Erection of extension to medical centre

R/207/09

Amendment to internal layout to provide for pharmacy

AS PROPOSED
WESTCOURT MEDICAL CENTRE, RUSTINGTON
 DRAWING NO 06.25/102D SCALE 1 : 250/100 @A1 DATE NOV 2006
GILES JOLLANDS Architect
 NORTH MARDEN BARN, NORTH MARDEN, CHICHESTER, WEST SUSSEX PO18 9JU
 TEL 01243 535 444

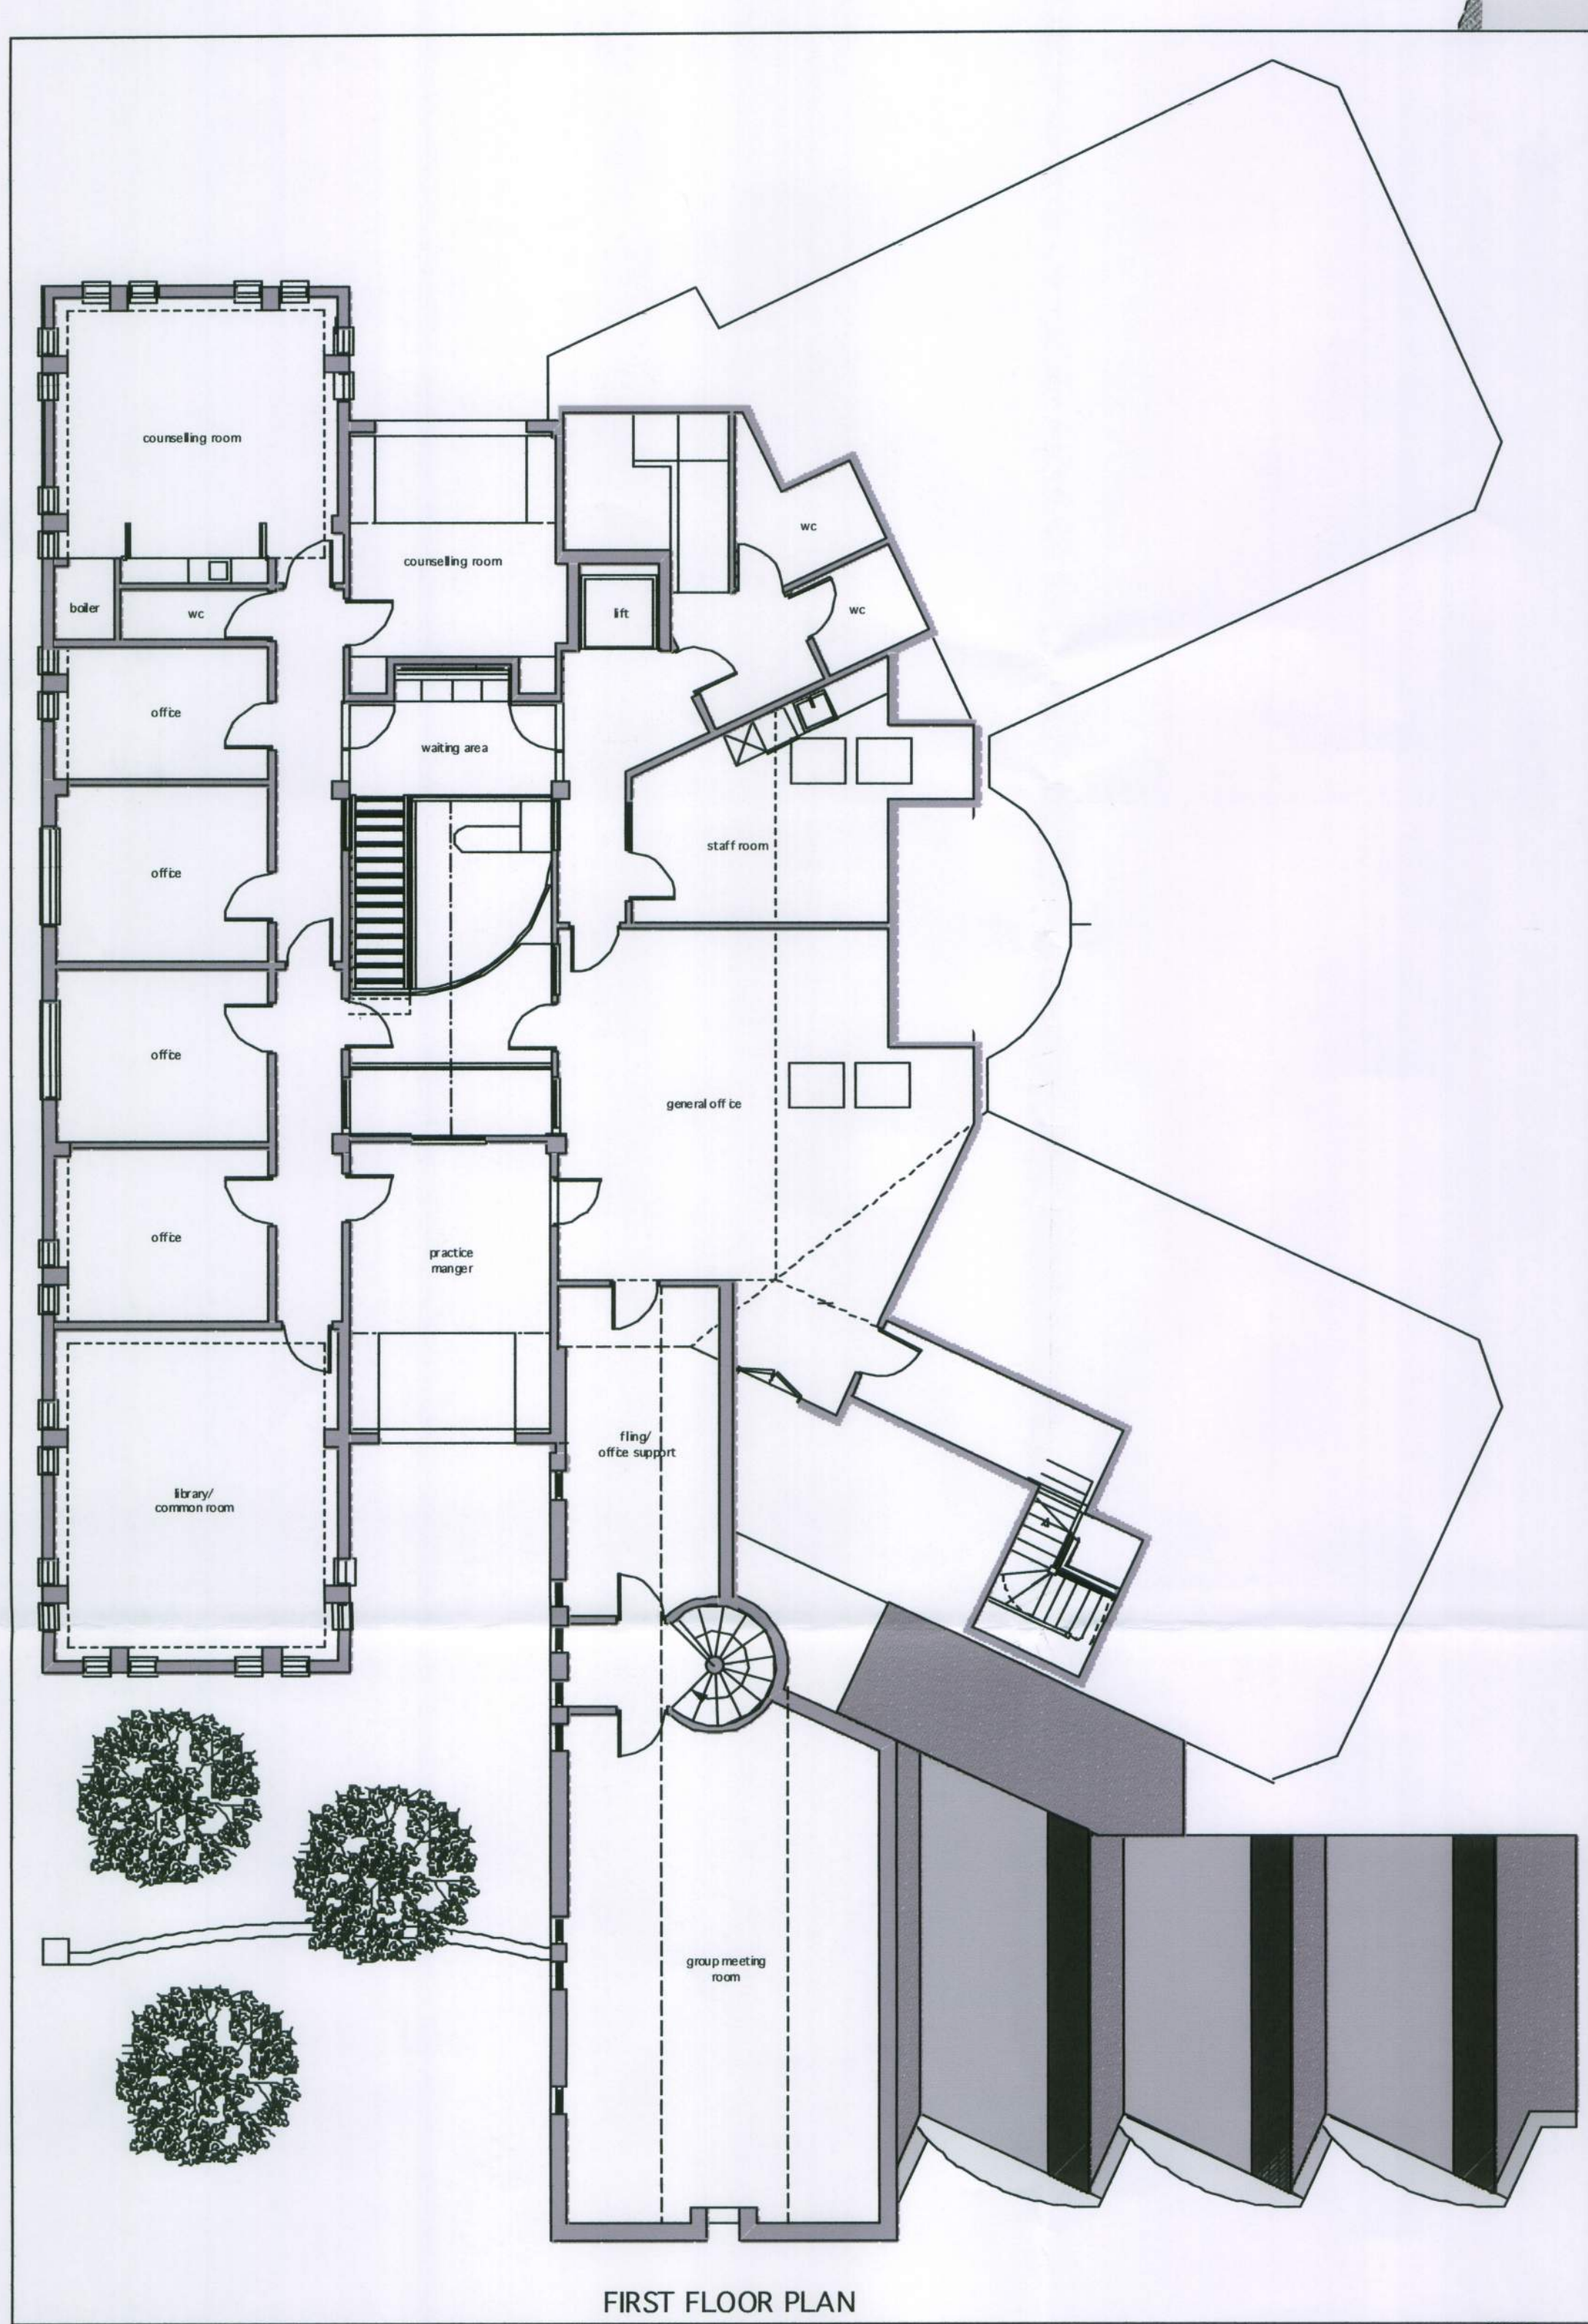
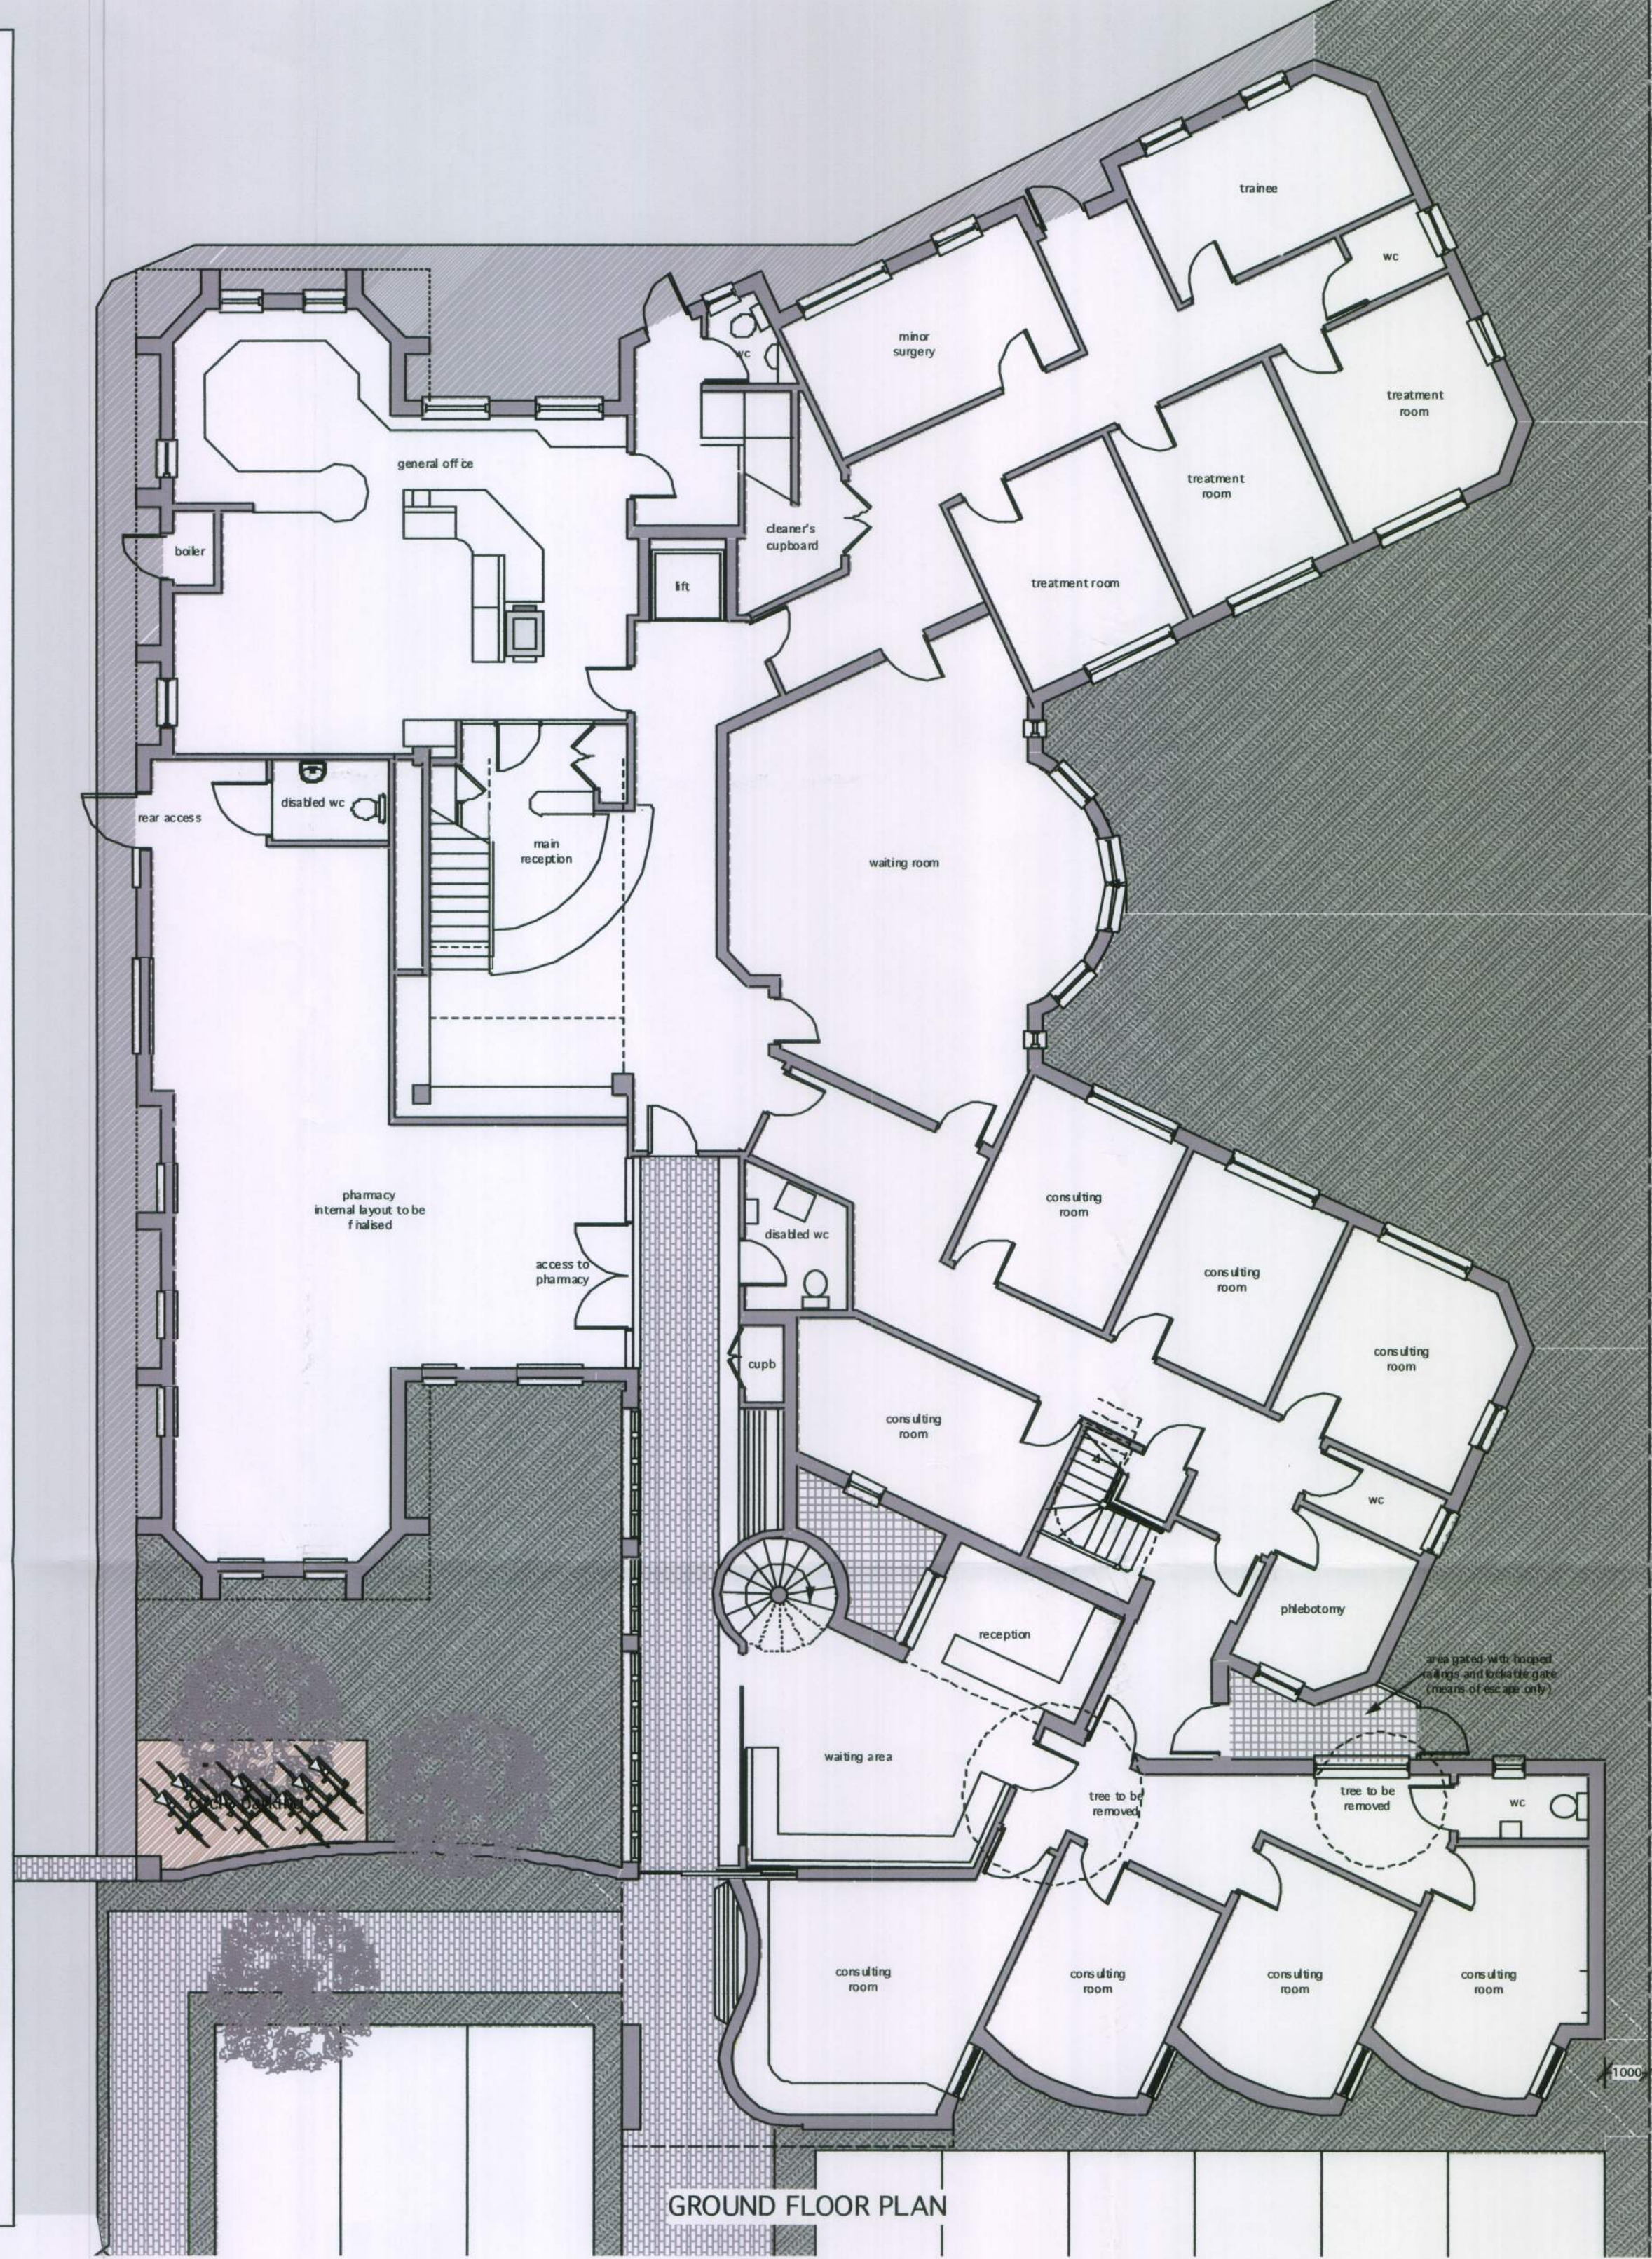
06.25/102B

06.25/102D
